Re: KAG Ford Service Center – PA23-024 – Technical Review 1
16100 Smokey Point Blvd – APN(s): 31052900400600

After review of the preliminary Site Plan Review, the Planning Division has the following comments:

Re: **Project Name:** Kendall Auto Group-Ford Service Center

Proposal: New construction of a 52,000 SF service center for medium-duty and super-duty trucks with 24 service bays. The facility is not intended for automobiles and standard pickup trucks.

A1 NORTH ELEVATION
A201 1/8" = 1'-0"

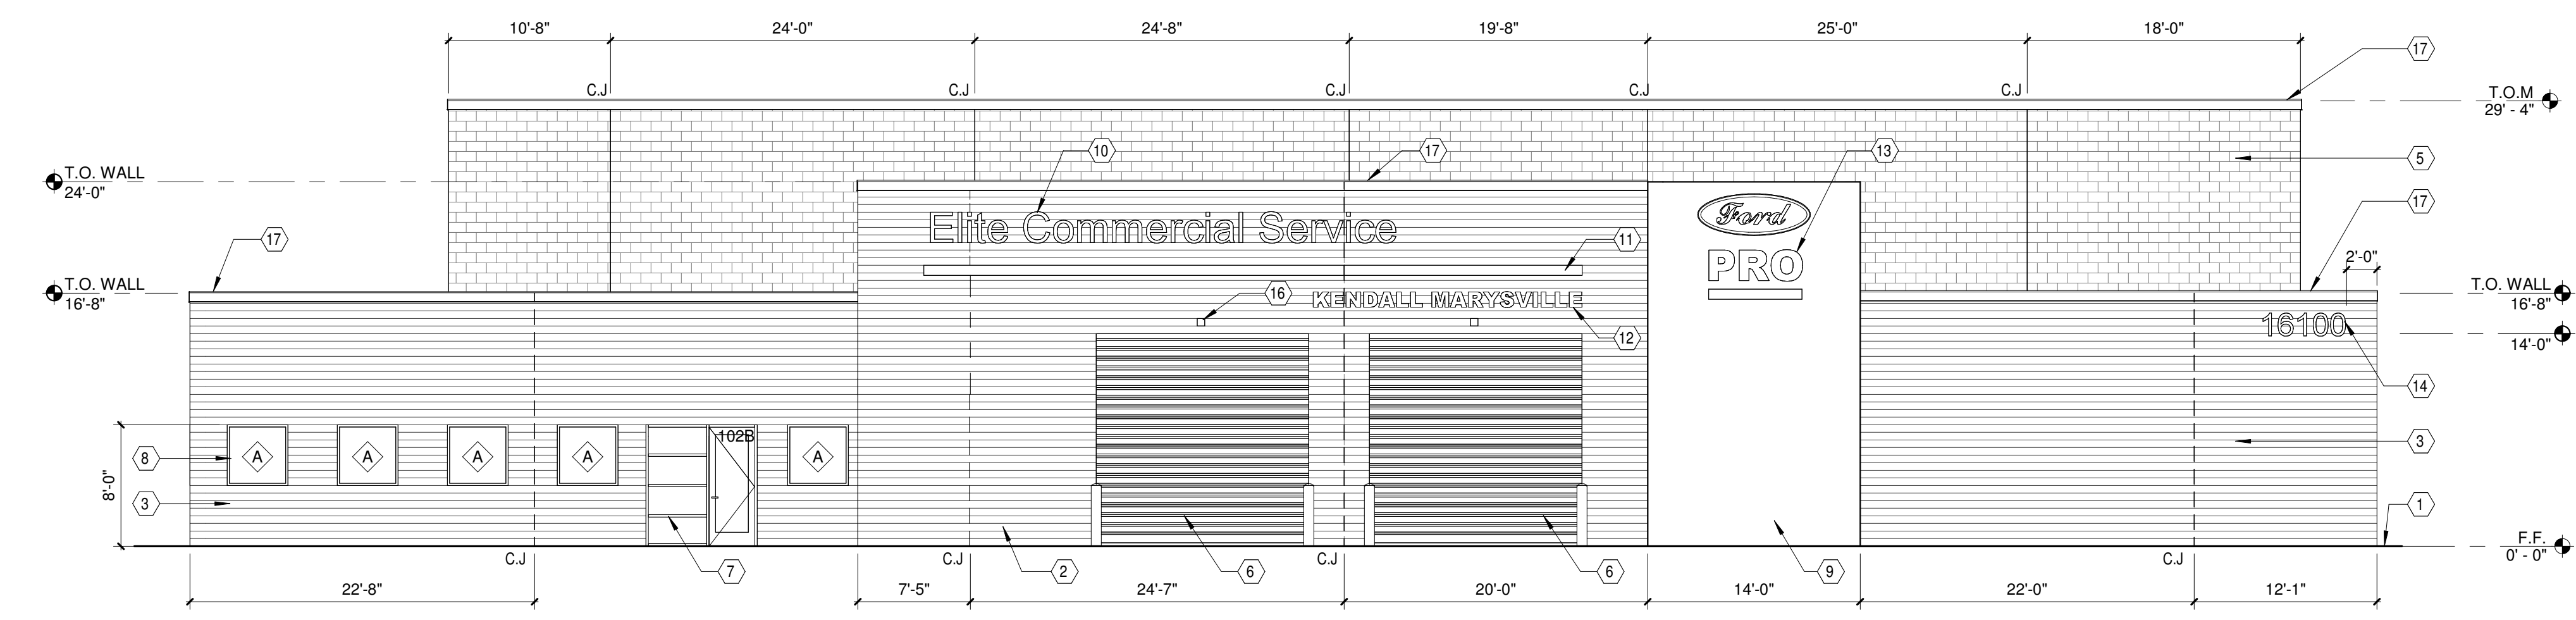
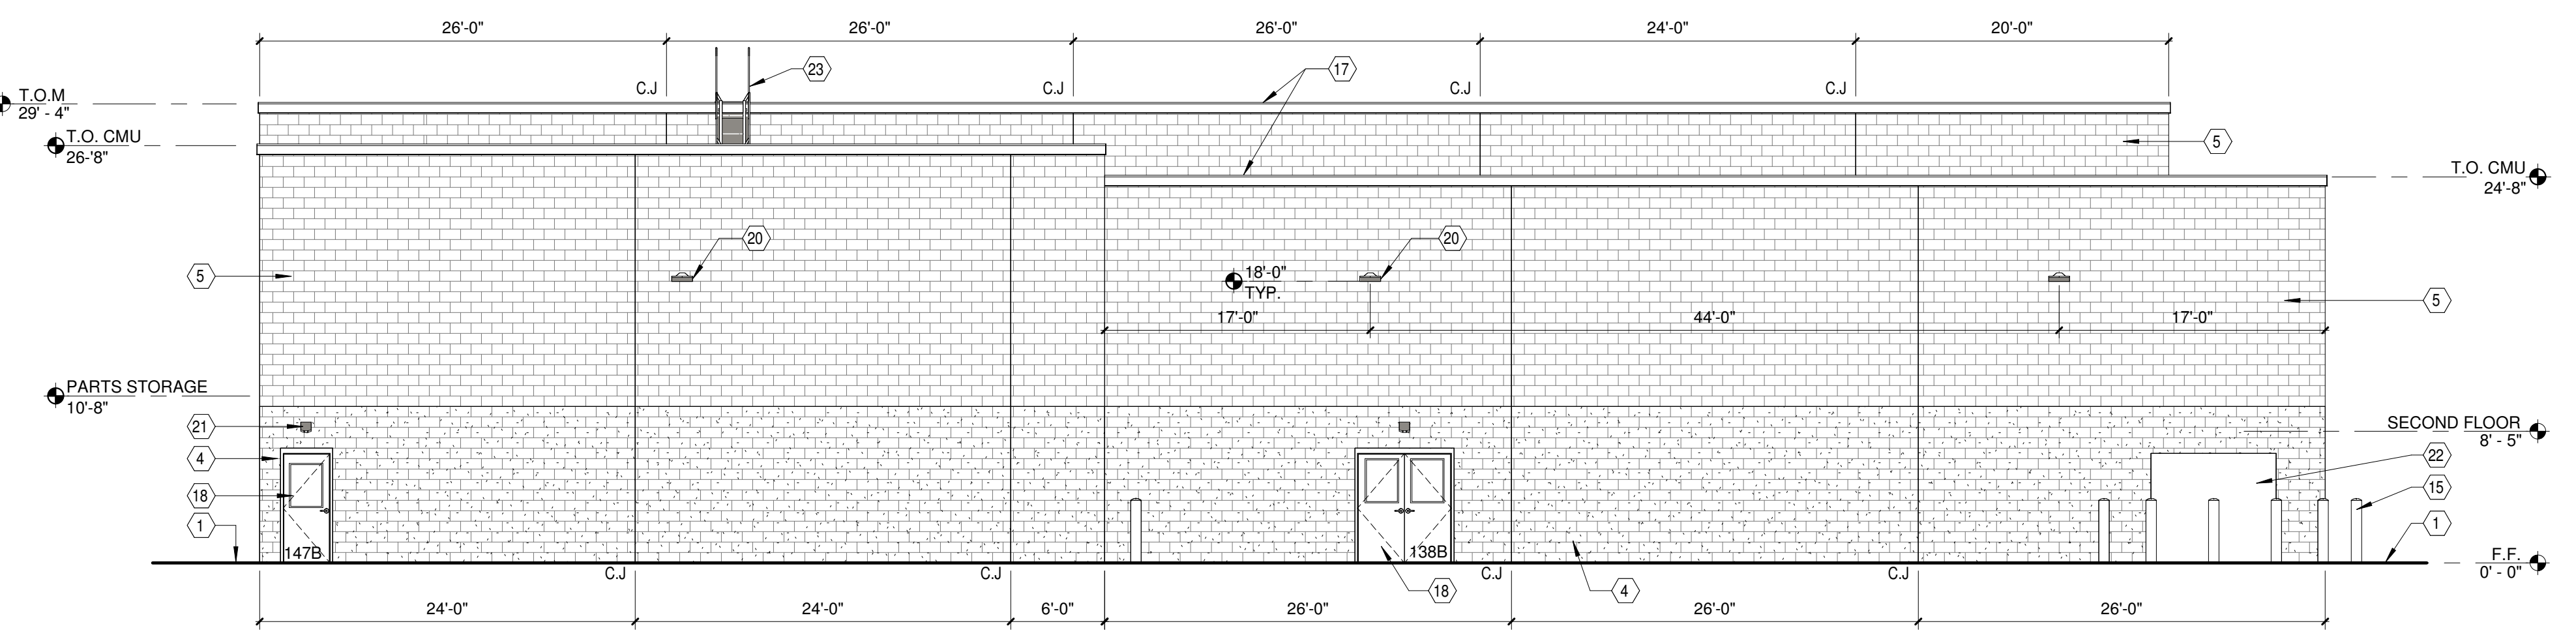
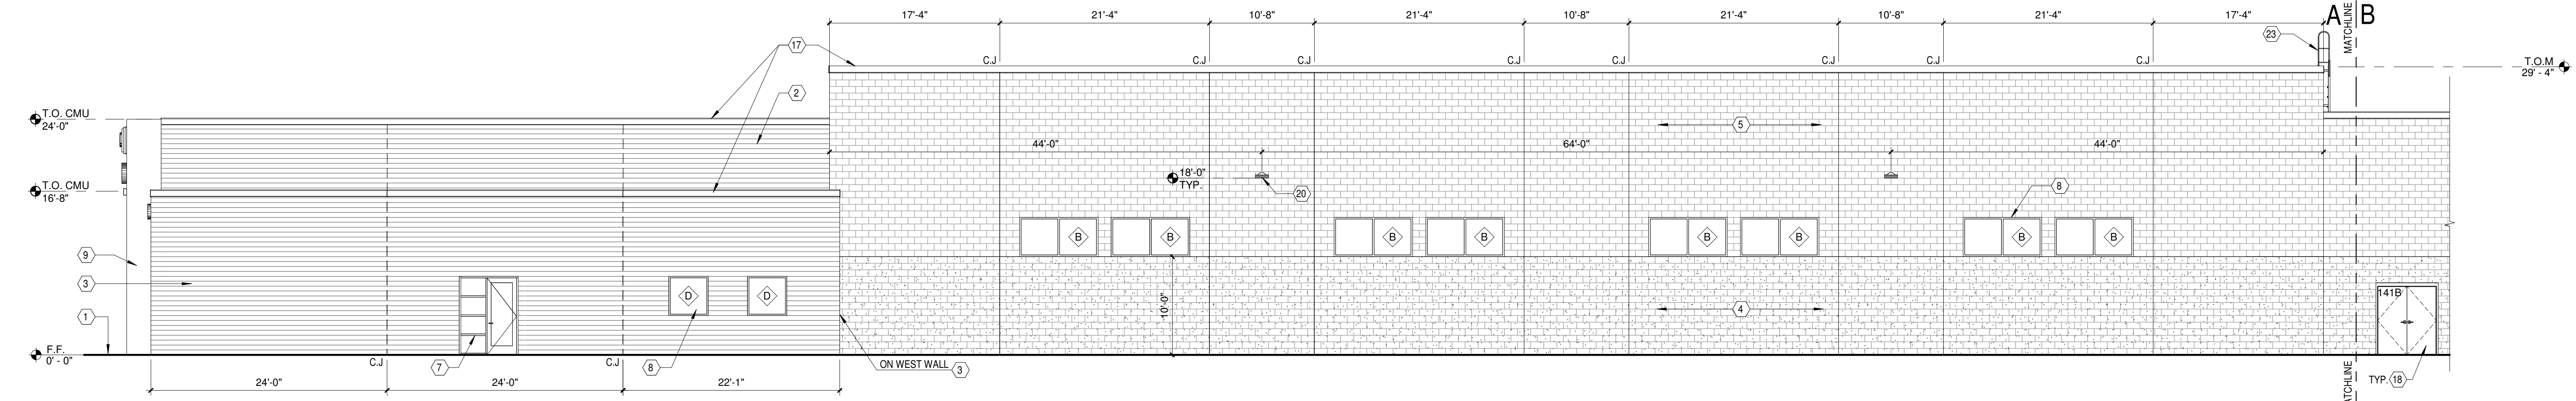
1. Provide file number PA23-024 on all future plan submittals.
2. Per MMC 22C.020.250(12), recessed entries for purpose of weather protection is permitted. Please demonstrate that the proposed recessed pedestrian entries meet the required dimensional requirements.

3. Demonstrate compliance with MMC 22C.020.340(2) - *Mechanical equipment located on the roof, facade or external portions of a building shall be architecturally screened so as not to be visible from adjacent properties at street level or the public street.*
